***Planning Department  
Transportation Development Services***

March 10, 2015

**Re: Sandia Area Federal Credit Union, 11301 Montgomery Blvd. NE  
Traffic Circulation Layout  
Plan Dated 03-02-15 (F22-D002)**

**TRAFFIC
CIRCULATION
LAYOUT**

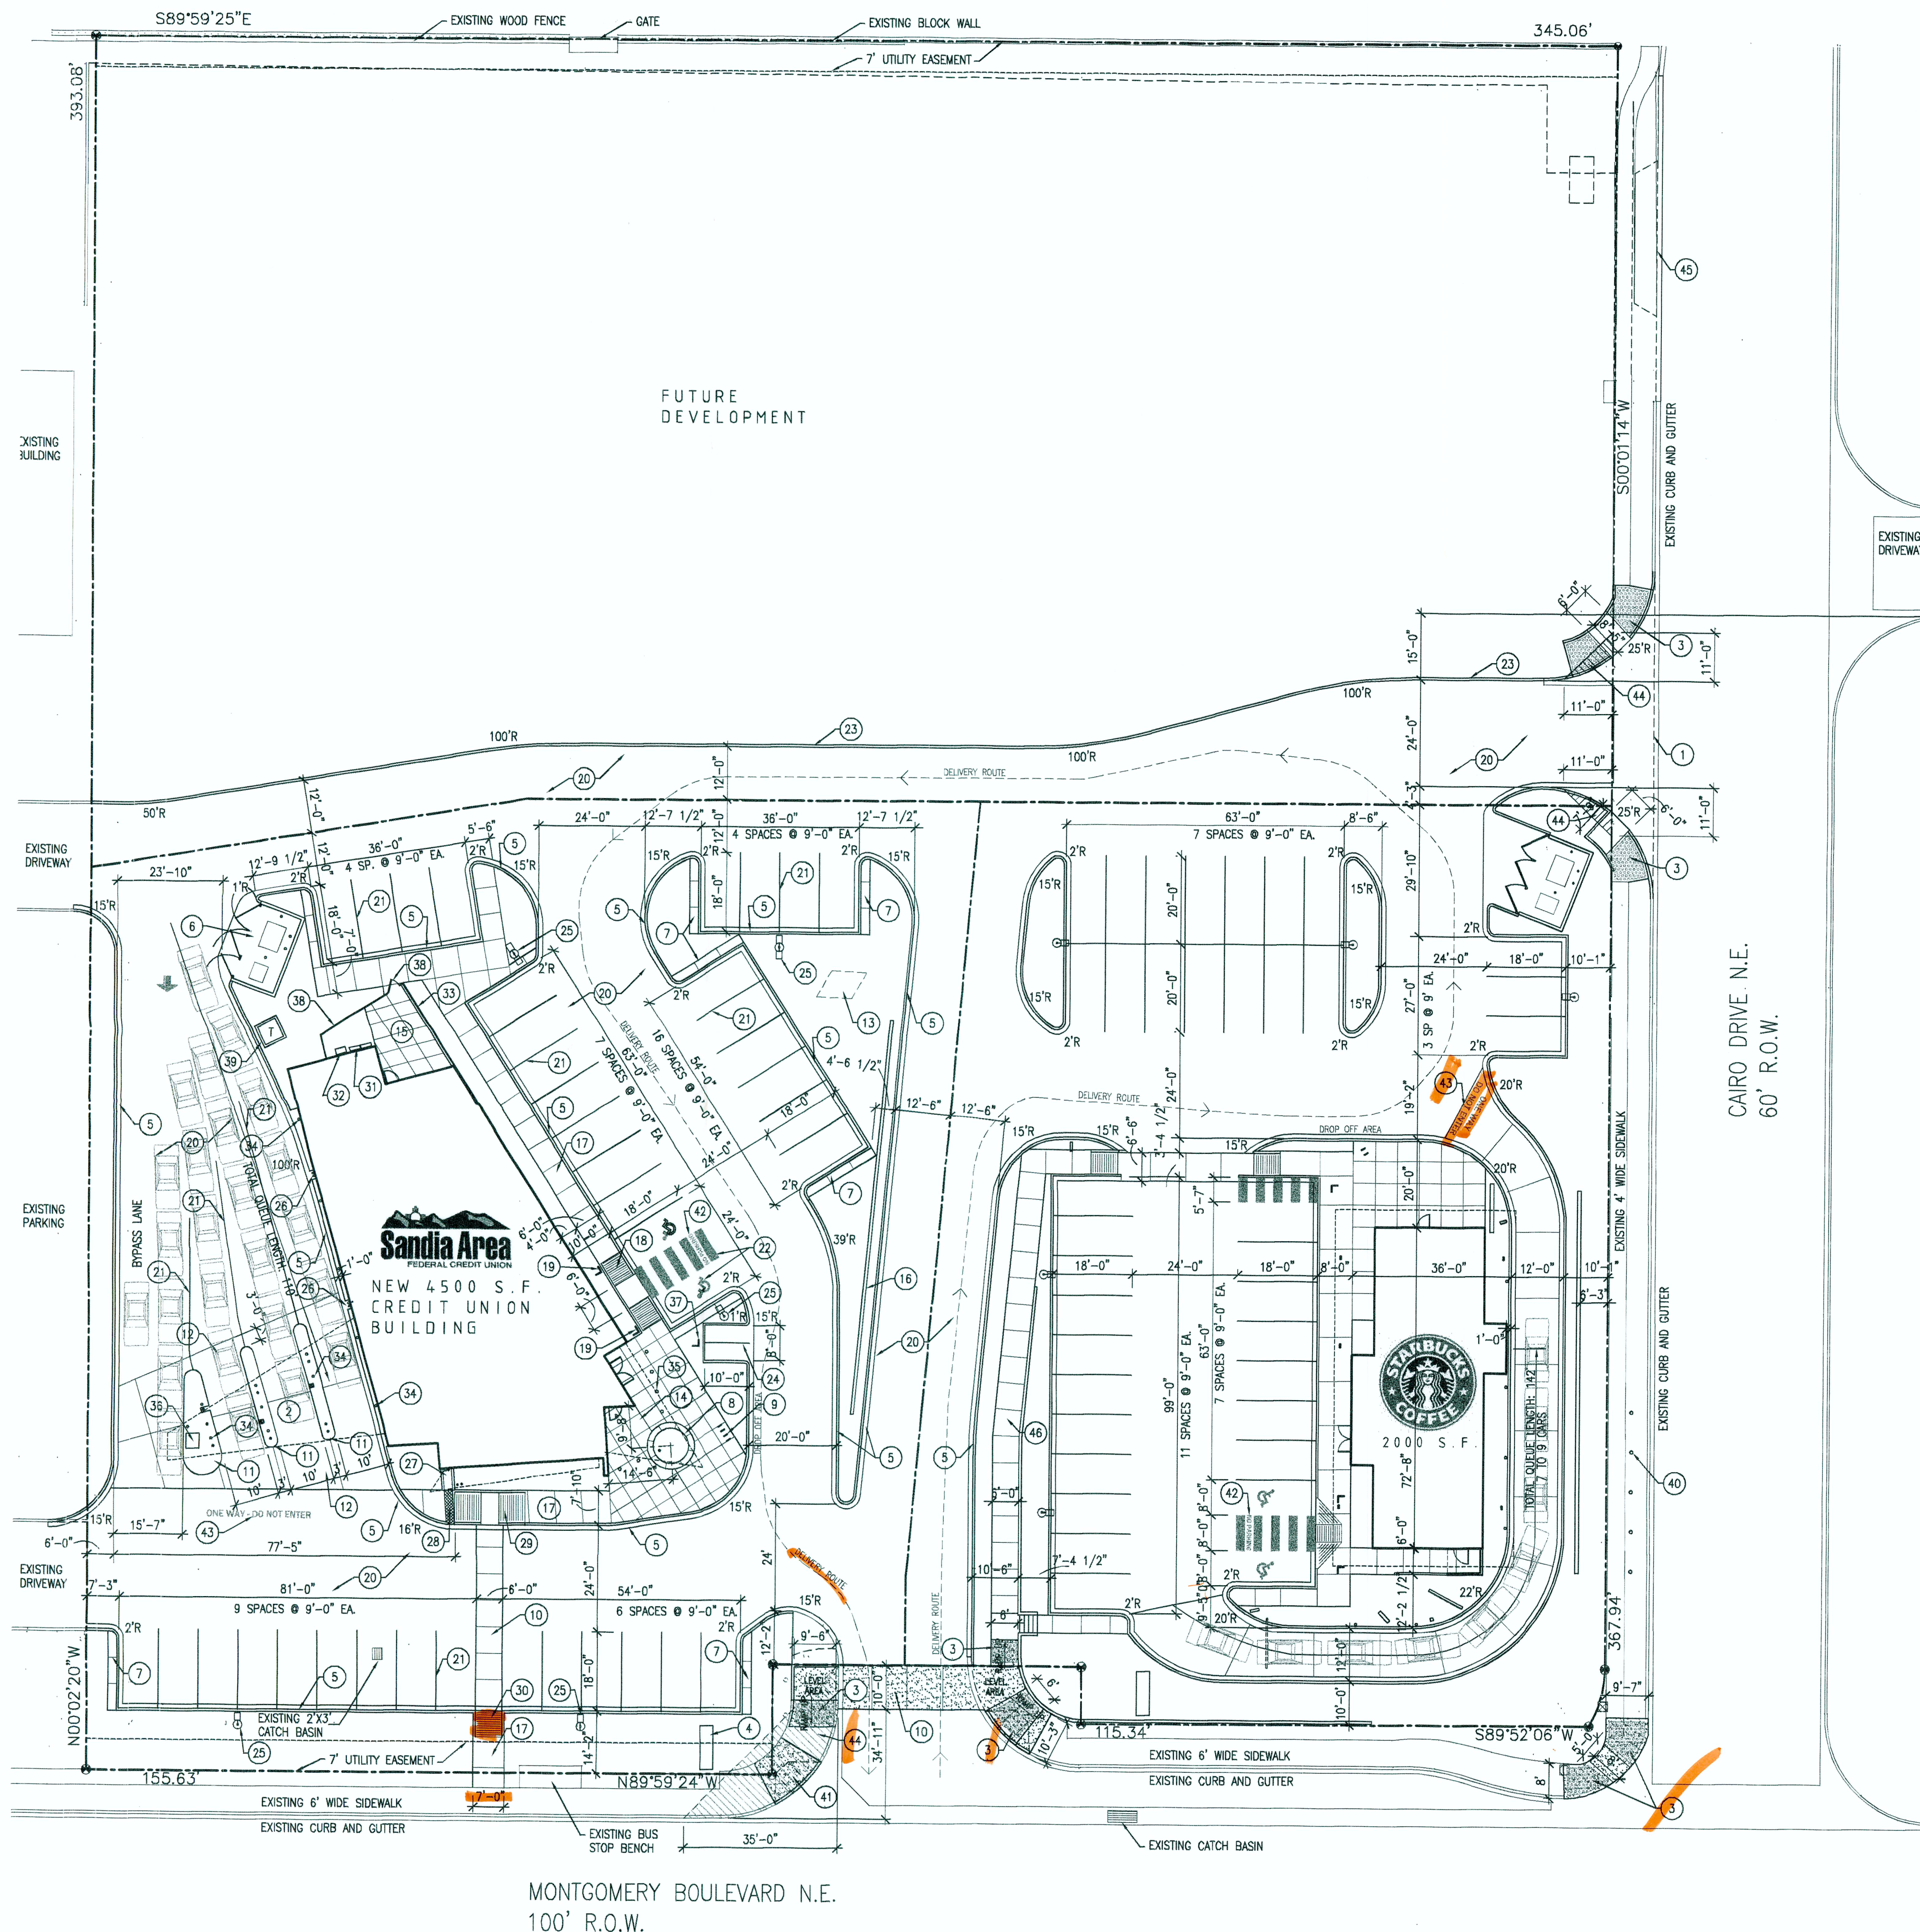
2. Show where new on-site curb begins and ends. Please differentiate between existing and new curb. It would be easier to show a different legend for the existing curb. It is still difficult to differentiate where existing and new side walk begin and ends. Please detail widths of existing and new sidewalks. Please show detail of truncated domes on drawing.

3. For ADA ramps called out by Keyed Note 18, 29 and 30, please show width and call out of a "2% Cross Slope" requirement.
4. For the 6-foot wide ADA accessible connection from Starbucks to the existing street right-of-way, please detail the width of ADA Crossing along with "2% Cross Slope" requirement for all handicap sections. It is required to have a 6 ft. ADA accessible pathway from the public right-of-way to the building entrances. After reviewing the drawing, it seems that the pedestrian sidewalk protrudes onto private property in-between Starbuck and Credit Union. The pedestrian crosswalk should be kept in the public R.O.W. Please clarify.

5. For the handicap ramp called out by Keyed Note 3, please provide a detail on the drawing with all dimensions and show existing crosswalk and how this crosswalk lines up with curb ramp. Call out existing mastarm and label proposed curb radius for this curb return.

6. Please call out detail for curb ramp at south-west corner of Starbucks. For this ramp, call out is a minimum width of 6 ft.
7. Please submit two copies of the Traffic Circulation Layout for the next submittal.
